From: Kate Giddings
Sent: 29 April 2019 17:50
To: Simon Davis
Cc: Anna Appleton; Planning.Responses
Subject: Y/29/19/DOC

In relation to the ground contamination aspect, I have now read (amongst other submissions) Ground Management Ltd.'s Verification Report (Phases 1-3) (ref.: G6308-04/03, dated April 2019) and would please request that the following queries are addressed:

SECTION: Verification Report - Phase 3 (Plots 2 - 8)

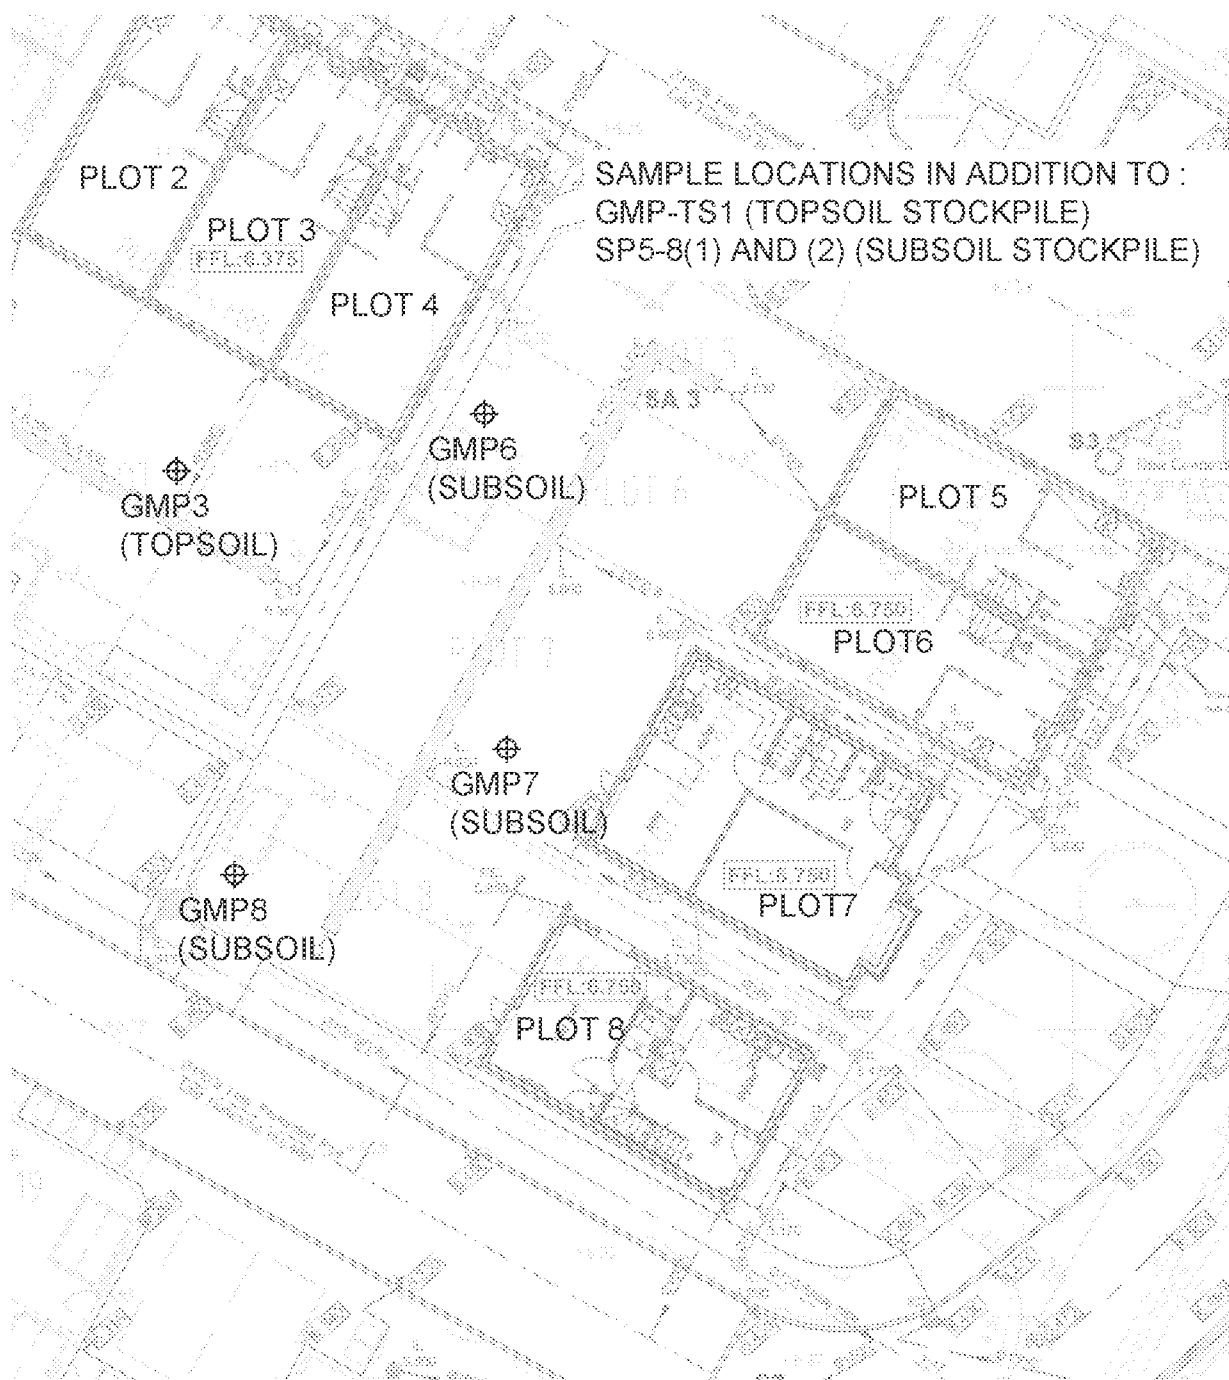
1. since the report was published, has any validation sampling been undertaken for the areas of soft landscaping to the front of plots 5-8?
2. since the report was published, has any validation sampling been undertaken in the area to the north of the site where topsoil placement was to be completed?

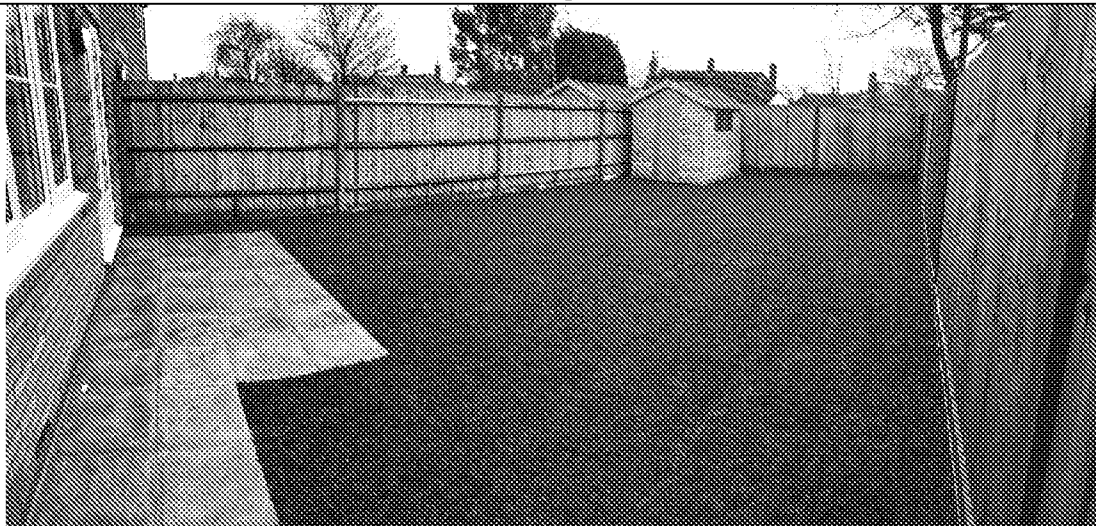
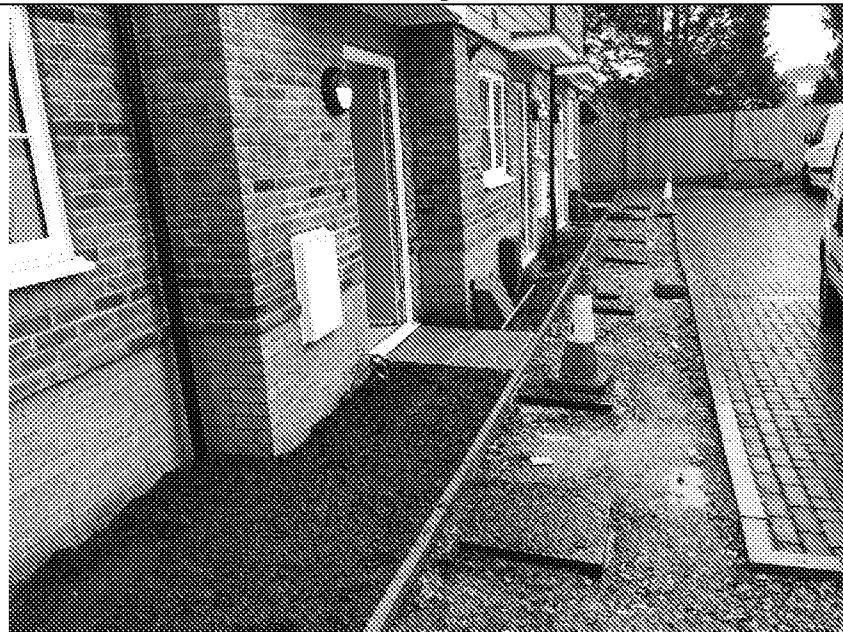
5. please may the photographs provided be made available in colour so that the placement of the geotextile membrane can be identified?
